Great Wolf Lodge, Chesterton, Bicester
Great Lakes UK Limited

Design & Access Statement Addendum

December 2021

This document has been prepared by EPR Architects in collaboration with the wider design team, to be read as an addendum to the original 2019 application (Application Ref. 19/02550/F (Appeal Ref: APP/C3105/W/20/3259189)).

2 Bay F - Plan  
1:50

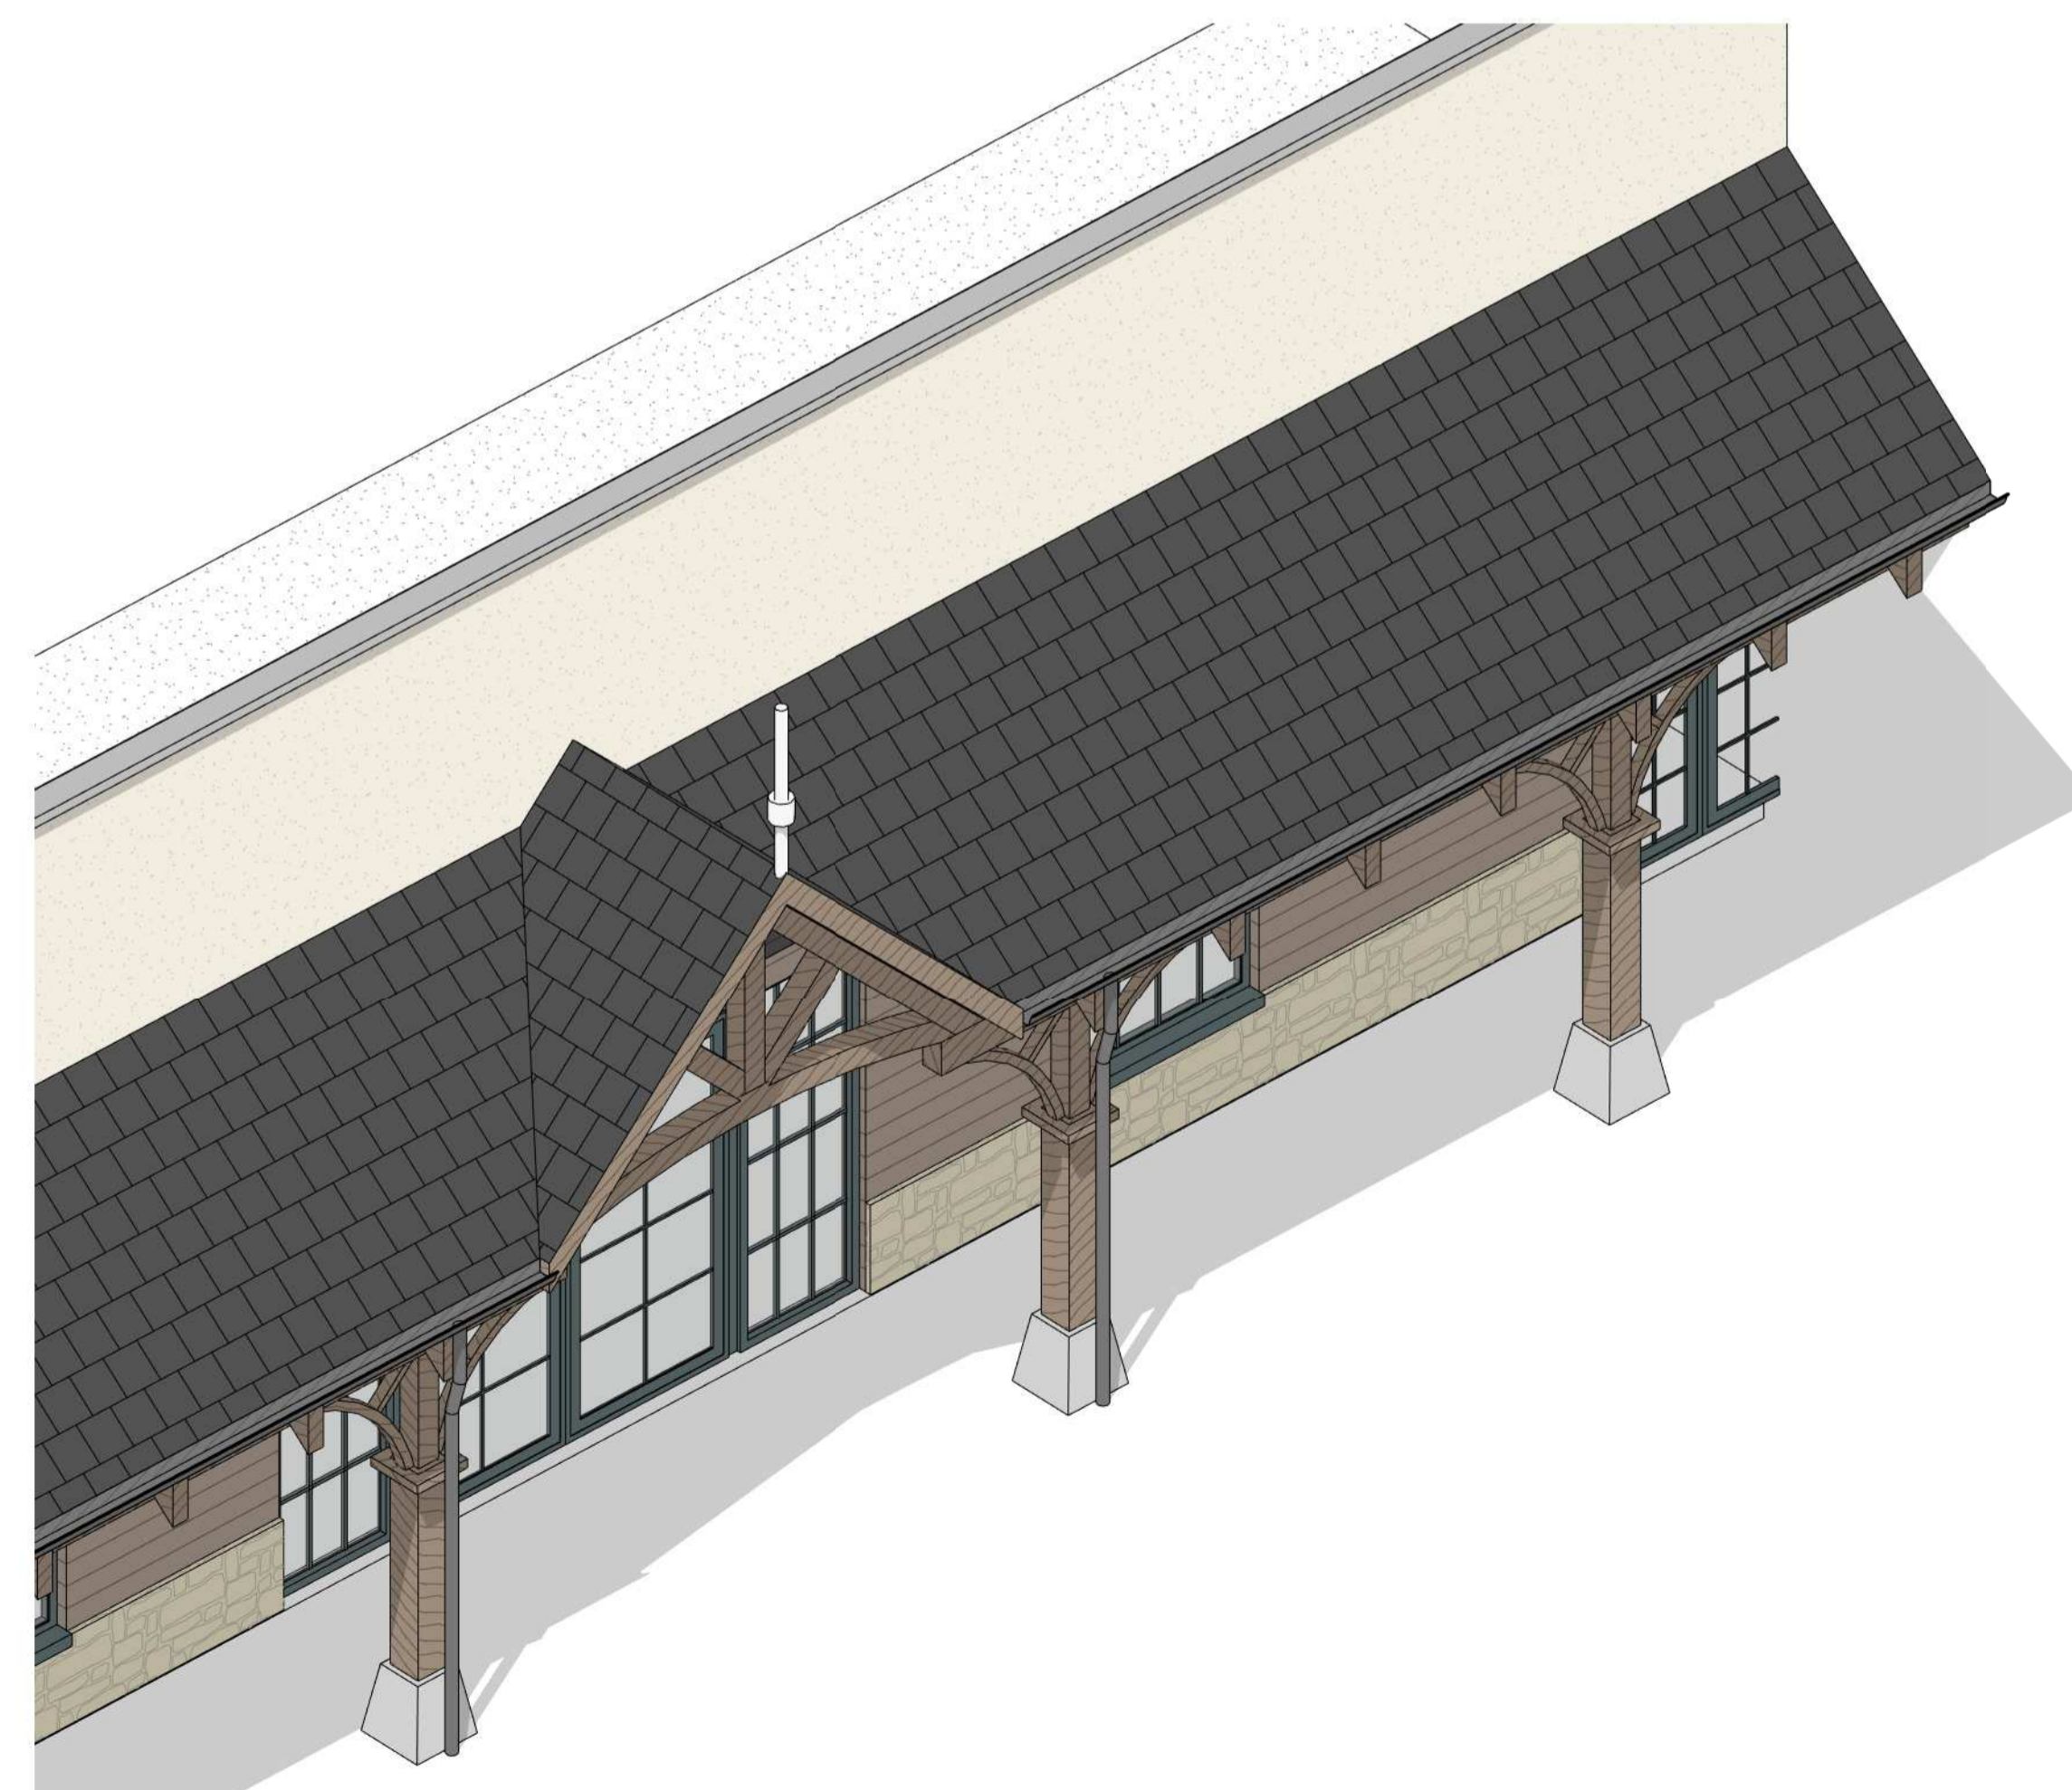
4. Re-configuration of the conference centre massing, facade design and internal layout.
5. External water park deck layouts revised and height levels updated to facilitate raised terrace zone with associated balustrade. Enlargened square to the South East corner created to host new outdoor whirlpool design.
